Our Ref: BR/217/20/NMA

**Section 96A of the Town & Country Planning Act 1990 (as amended)
Town and Country Planning (Development Management Procedure) (England) Order 2015 (as amended) - Article 10**

Non-material amendment following grant of BR/257/17/PL to move entrance door's location, move staircase location and to replace window on rear elevation at the ground floor level with French doors.
12 Tennyson Road Bognor Regis PO21 2SB

Scale: 1:100	Drawn:	Checked:	Approved:	Date: 29.08.2017
Job No: 1305	Drawing No: 102		Revision: B

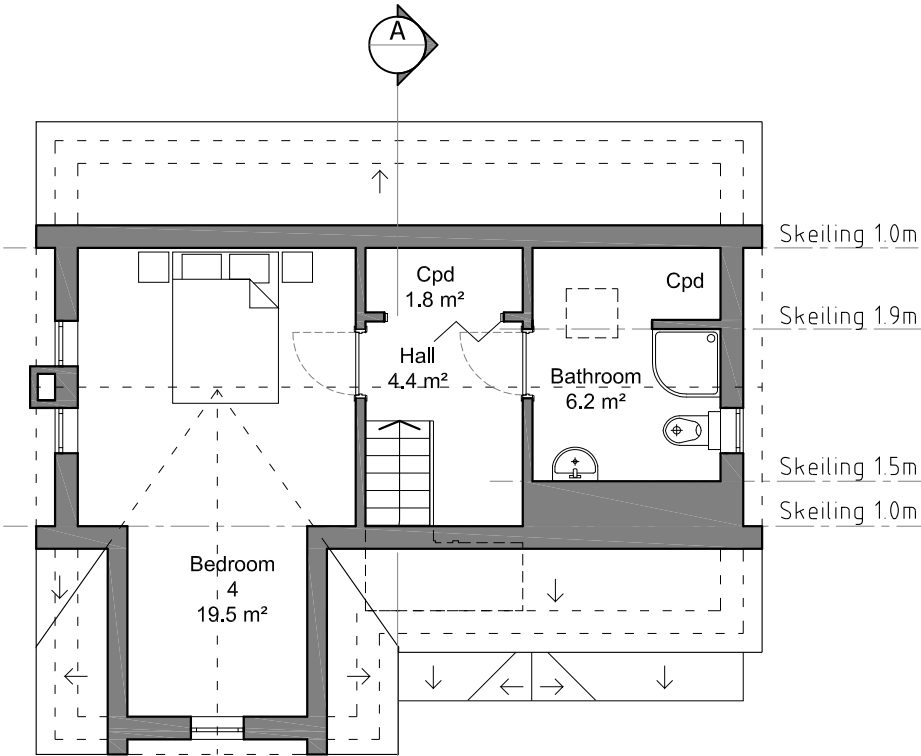
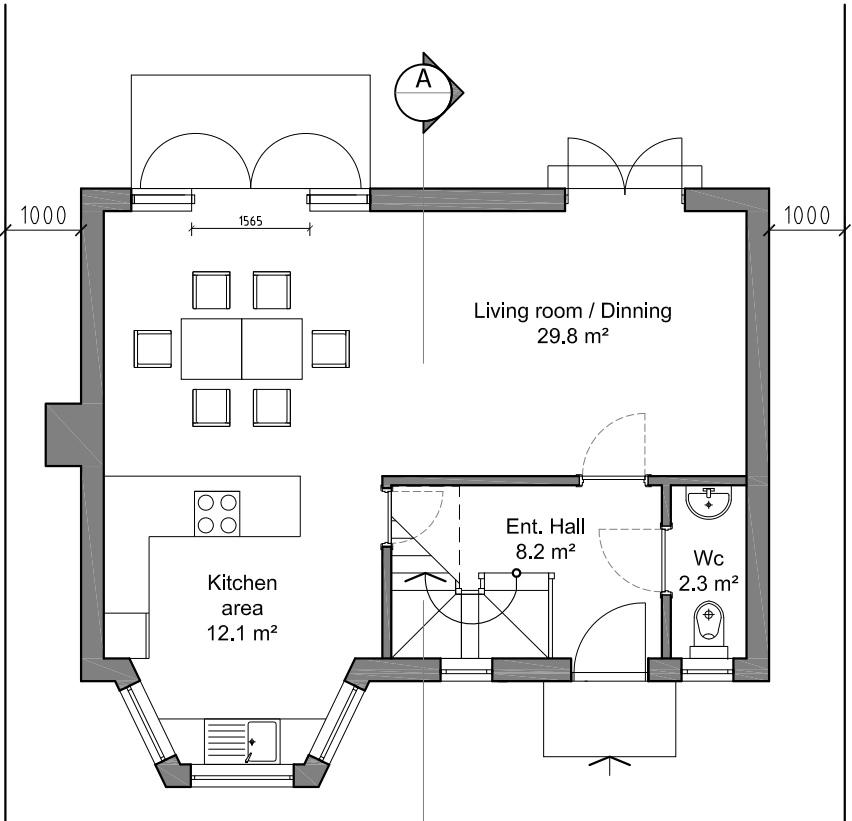
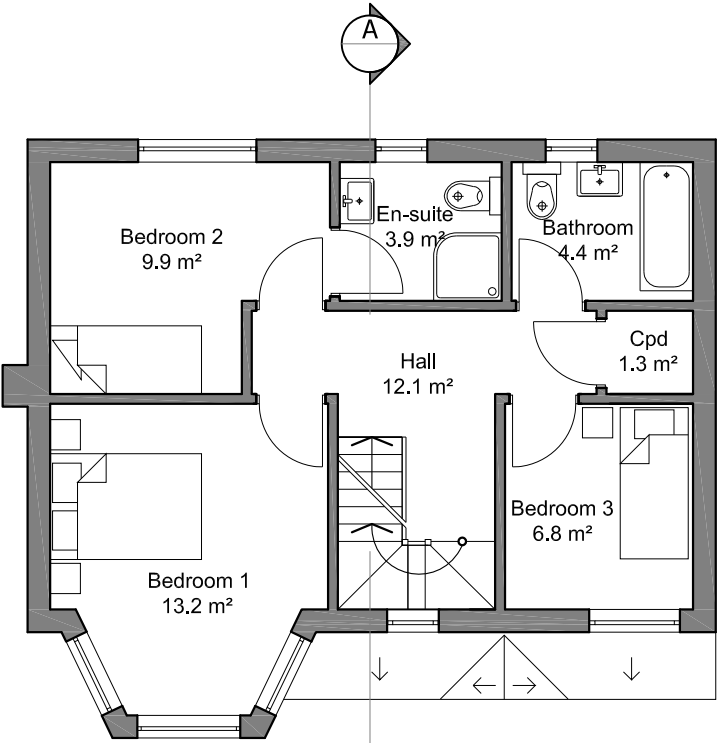
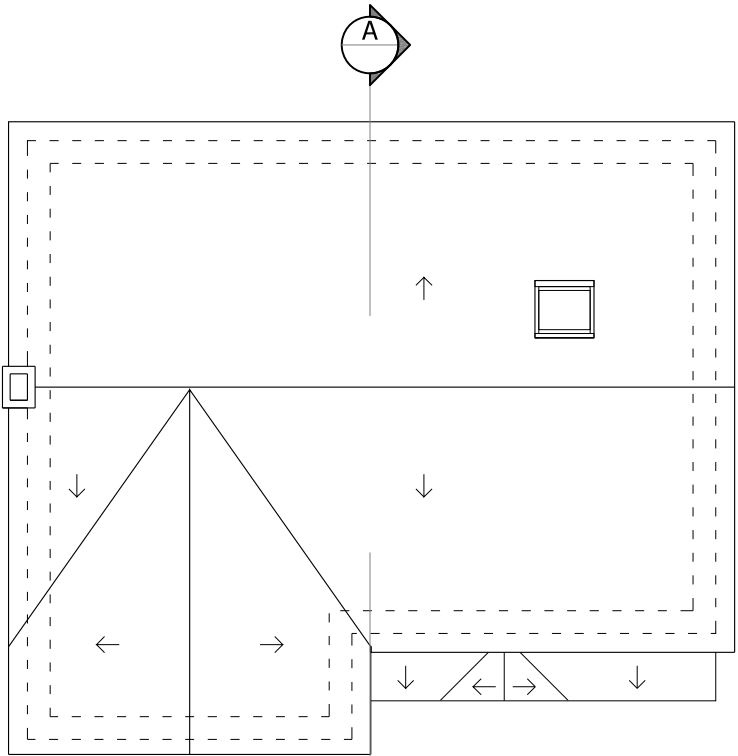
Please note that the drawing 102 B replaces the originally approved 102 and the drawing 103 B replaces originally approved 103.
